**2** | PERVIOUS AREA  
1" = 30'-0"

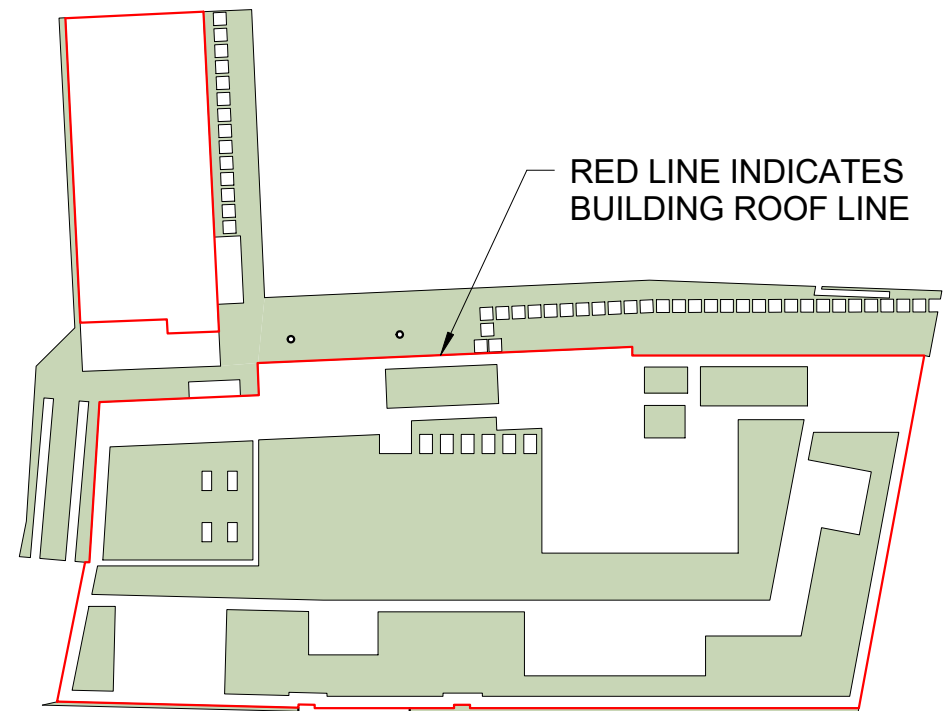
The roof overhang should be removed from this pervious total.

This number should be the exact sf of total pervious on the site. As long as the number is at least 5,135 sf then meets standard.
